Name of Project: NC 27 & Ponderosa Corner

June 20, 2012

Application Number 11-50026676

Michael L. Martin
Chief Deputy Fire Marshal

SHEET C-1

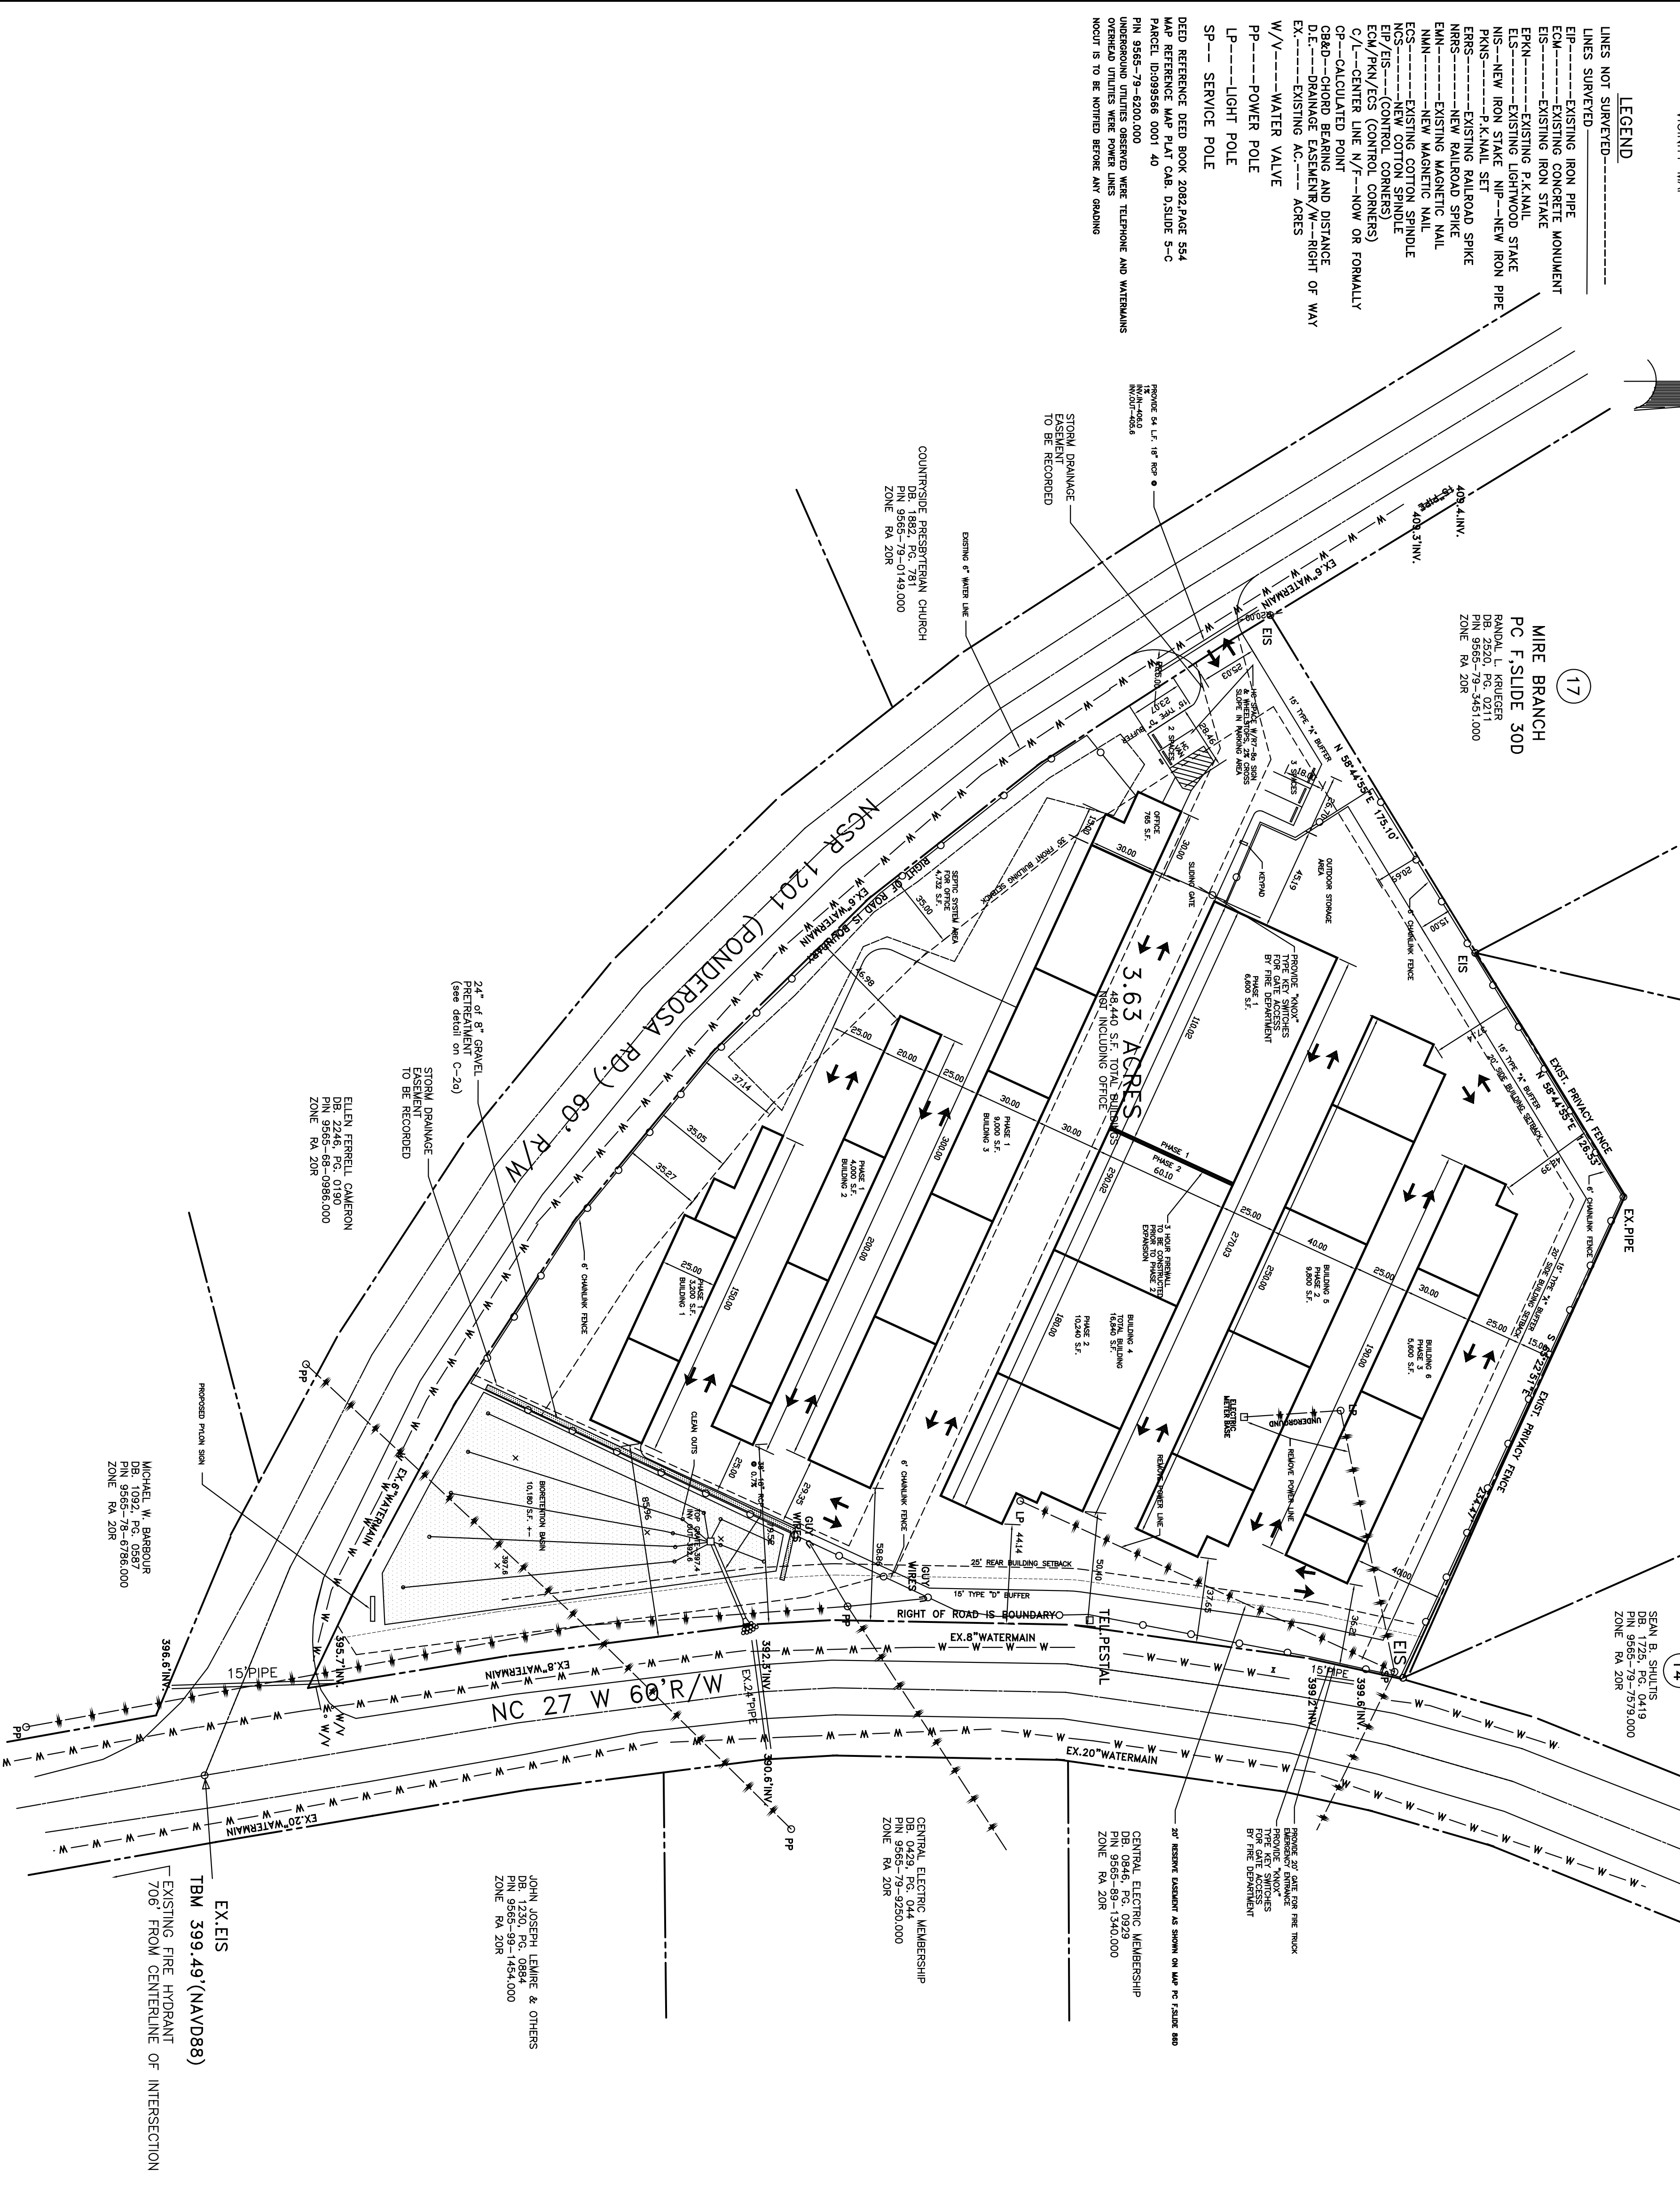
- Fire extinguishers shall be placed in approved locations as drawn by the code enforcement official on the approved plans.
- The fire extinguishers provided shall have a minimum rating of 2A 10B:C and shall not be installed higher than 5 feet above the finished floor
- Fire extinguishers shall be installed in such a manner that no distance to an extinguisher is greater than 75'

- A secure key box shall be installed on the new building that houses all keys to all the doors within the building in which the fire department would need access to in the event of an emergency.
- Knox Box ID stickers shall be placed on all exterior doors in which entry to the building may be gained. Stickers are to be ordered through the order form.
- The box shall be mounted not to exceed 48 – 60 inches in height.
- An authorized order form is included with this letter.

- **506.1 Knox Switch**
 - A Knox key switch shall be installed on the gate access for the facility to facilitate access by emergency personnel.
 - The Knox Switch can be ordered through the same form as the Knox Box.
 - A Knox Switch needs to be installed at every vehicle gate access into the facility.

- **505.1 Physical Address**
 - The physical address of the building shall be posted in a conspicuous place so that it can be seen on approach from the road, access road, and/or parking lot.
 - The numbers used to make up the physical address shall be at least 5 inches in height.
 - The address shall be posted on the interior of the building indicating the suite location in a conspicuous manner.
